**Consultation Response from KC,
Highways Development Management**

2024/91316 Clough House, 236, Leeds Road, Birstall, Batley, WF17 0HW

Conversion of existing dwelling and outbuilding to create 6 apartments and erection of 17 dwellings

Date Responded: 21-8-2024.

1 PROPOSED SITE LAYOUT  
1 : 500

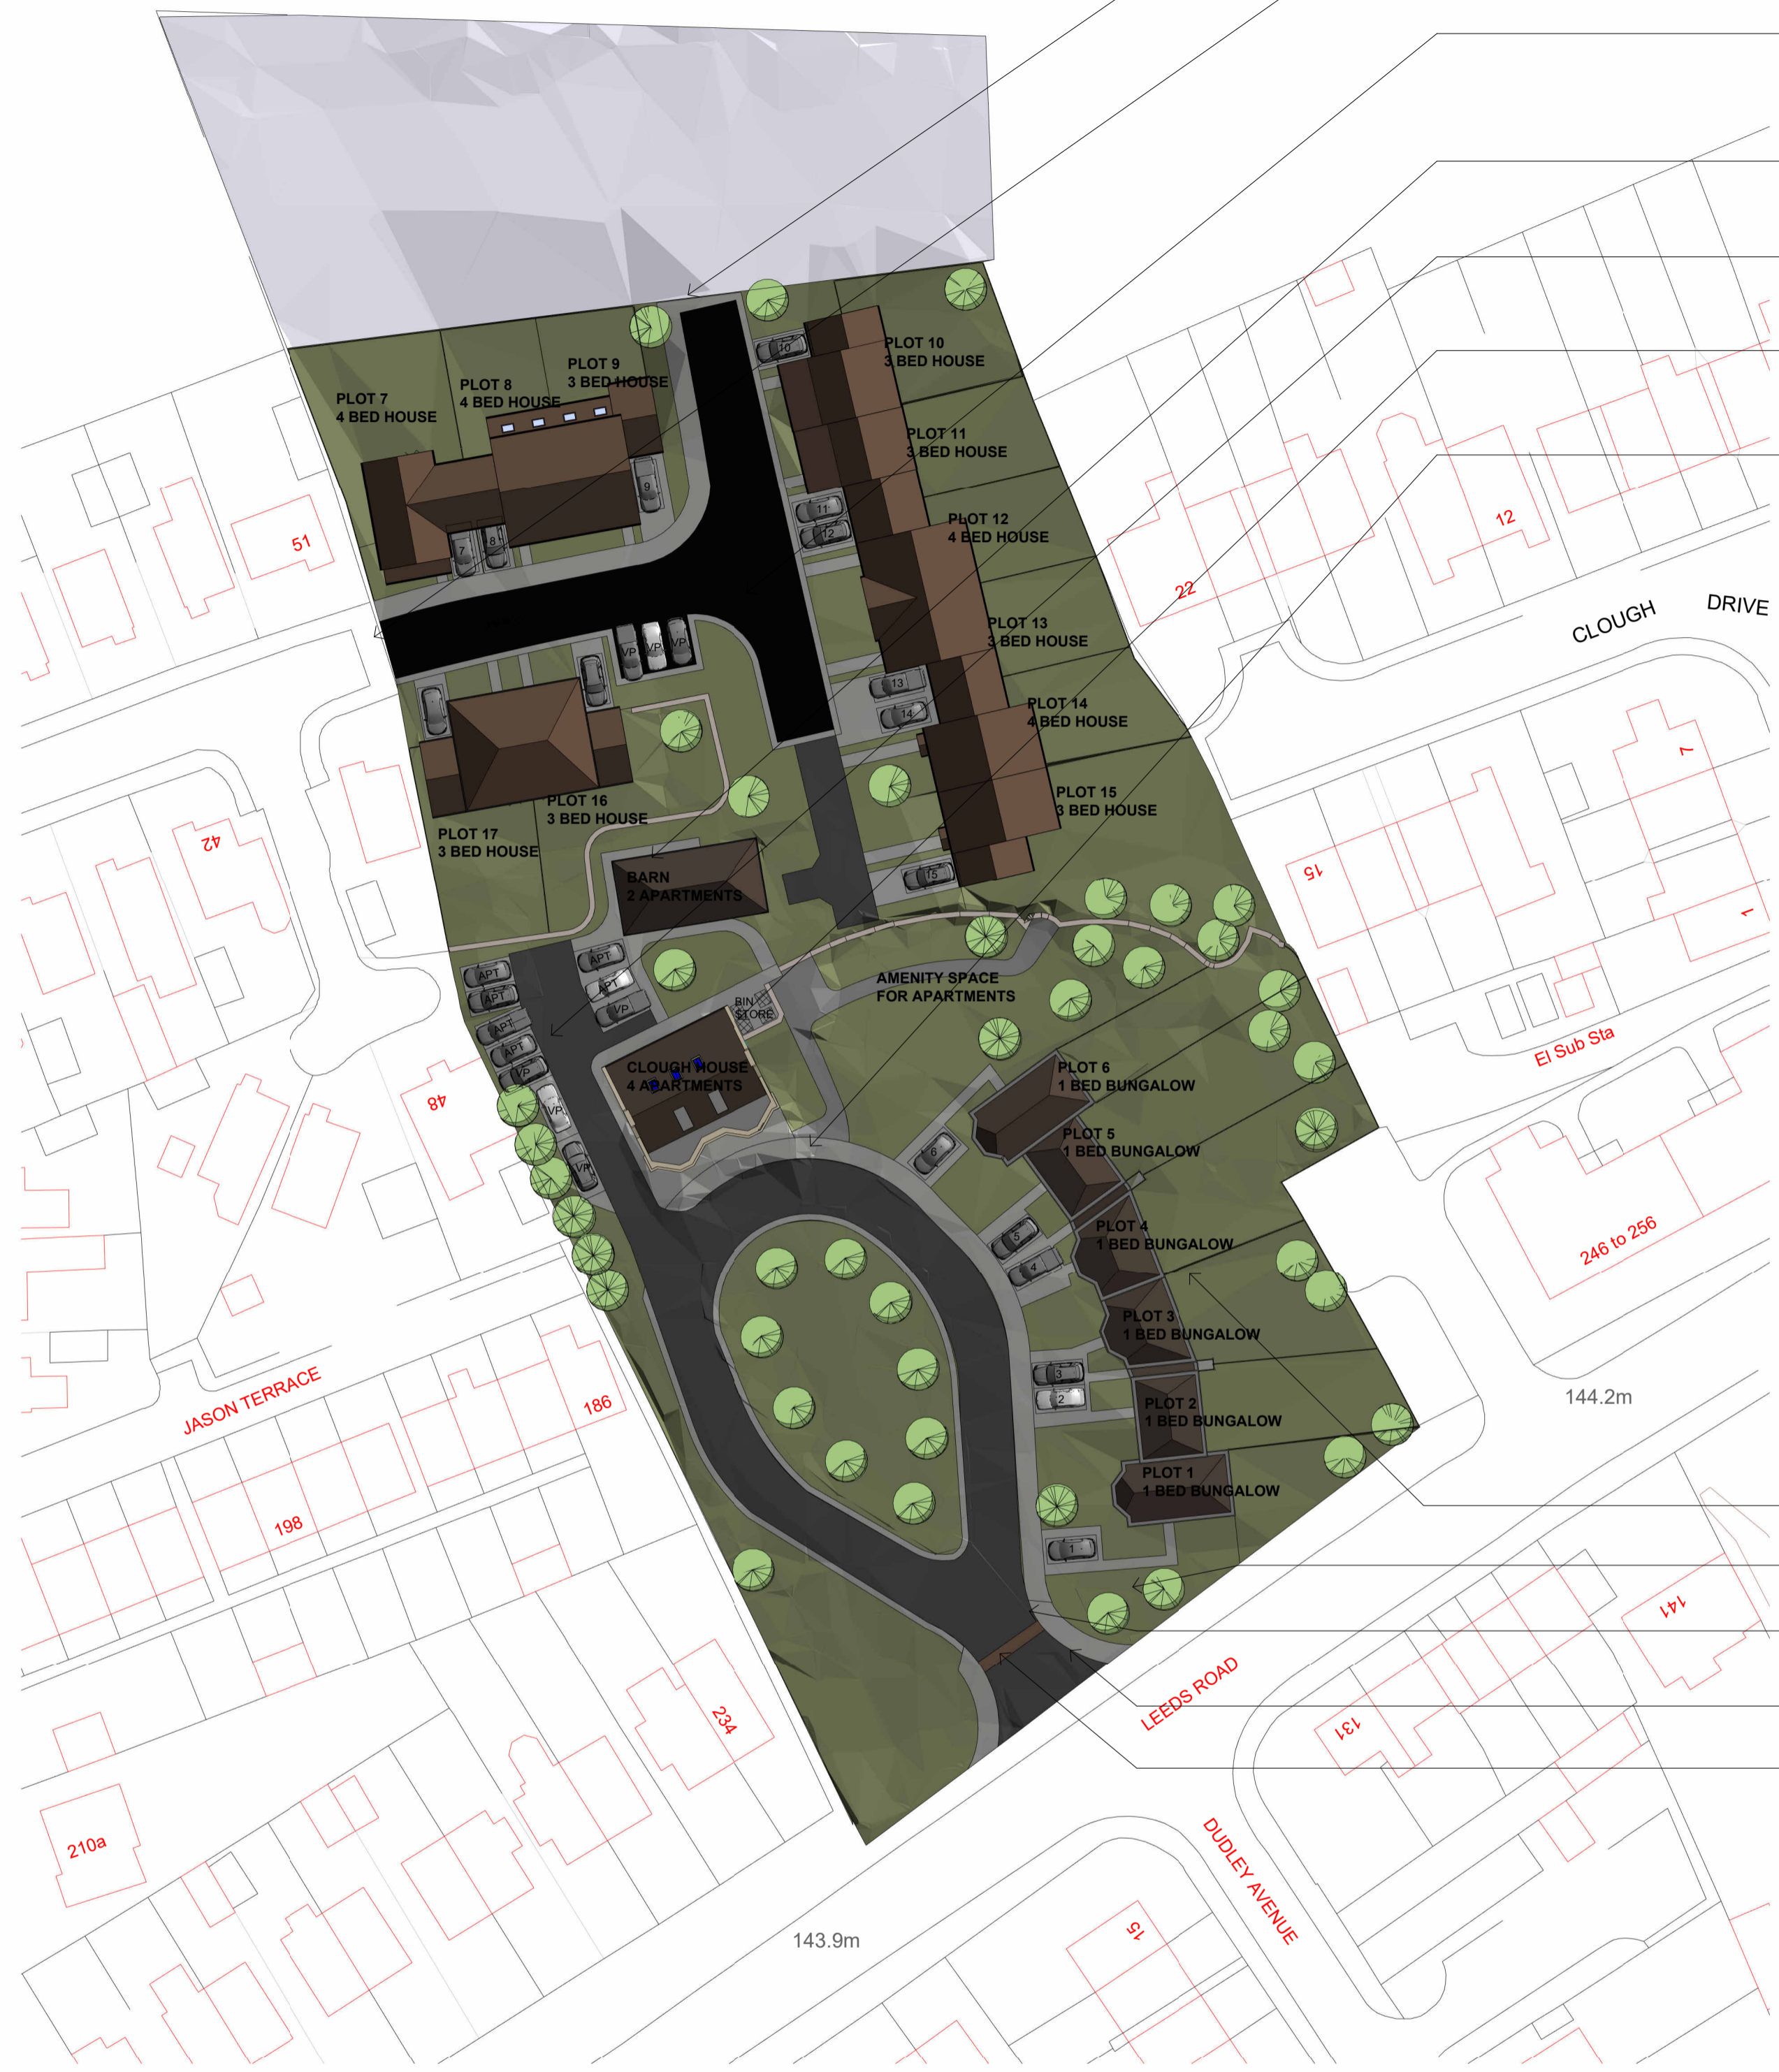
1, Can the applicants clarify whether they consider this road to be a shared surface carriageway of traditional estate road. For a shared surface carriageway, the maximum gradient acceptable is 1 in 20,

for a traditional estate road footway should be provided to both sides.

2, The visitor parking shown is not adoptable and not well spaced through the site. This needs to be reconsidered. If on street visitor parking is proposed the refuse vehicle swept path vehicle tracking should show the parking will not obstruct the refuse vehicle at all feasible locations.

3, Plots 7 and 8 are 4 bedroomed dwellings and require 3 of-street parking spaces only 2 are shown.

4, Bin storage is shown but not collection points. These need to be shown to be provided for all dwellings (flats and houses).

5, A detail of the proposed tie in between the proposed access road and Moat Hill Farm Drive should be provided with the existing footway across the turning head shown to be removed.

6, Fully dimensioned drawings should be provided.

7, A longitudinal section should be provided showing the proposed highway gradients.

1, For a shared surface carriageway, the maximum gradient acceptable is 1 in 20 or a traditional estate road should be provided with footways to both sides.

2, Bin storage is shown but not collection points. These need to be shown to be provided for all dwellings' flats and houses.

3, The junction radii are not properly drawn and is not dimensioned. This needs to tie into the Leeds Road carriageway.

4, Fully dimensioned drawings should be provided.

5, A longitudinal section should be provided showing the proposed highway gradients.

6, Access to the second visitor parking space for the apartments will be difficult with no splay onto the access road.

There are no visibility splays indicated. Junction and Forward Visibility Splays and dimensions (min 23 metres) must be in accordance with the Kirklees Design Guide (Table 1) and dedicated to Kirklees if they fall out of the existing highway boundary. The trees may have to be moved back once the forward visibility splay is identified.

Kirklees require a swept path analysis for an 11.85m in length refuse vehicle indicating how it can pass an on-coming or parked family car throughout the layout. The carriageway will require widening on the bends to enable this manoeuvre. The current proposal does not enable the refuse vehicle to pass an on-coming or parked car, please amend and resolve.

Footways will be required on both sides of the carriageway to a minimum width of 2.0m as per Table 1 above.

Where there is not a footway adjacent to the carriageway a minimum 5.5 metre wide shared surface block paved carriageway with a minimum 600mm block paved margin on either side is required as per Table 1 and paragraph 3.14 of the Design Guide. Shared surface carriageway must not be steeper than 1:20 otherwise a typical carriageway with footways each side will be required.
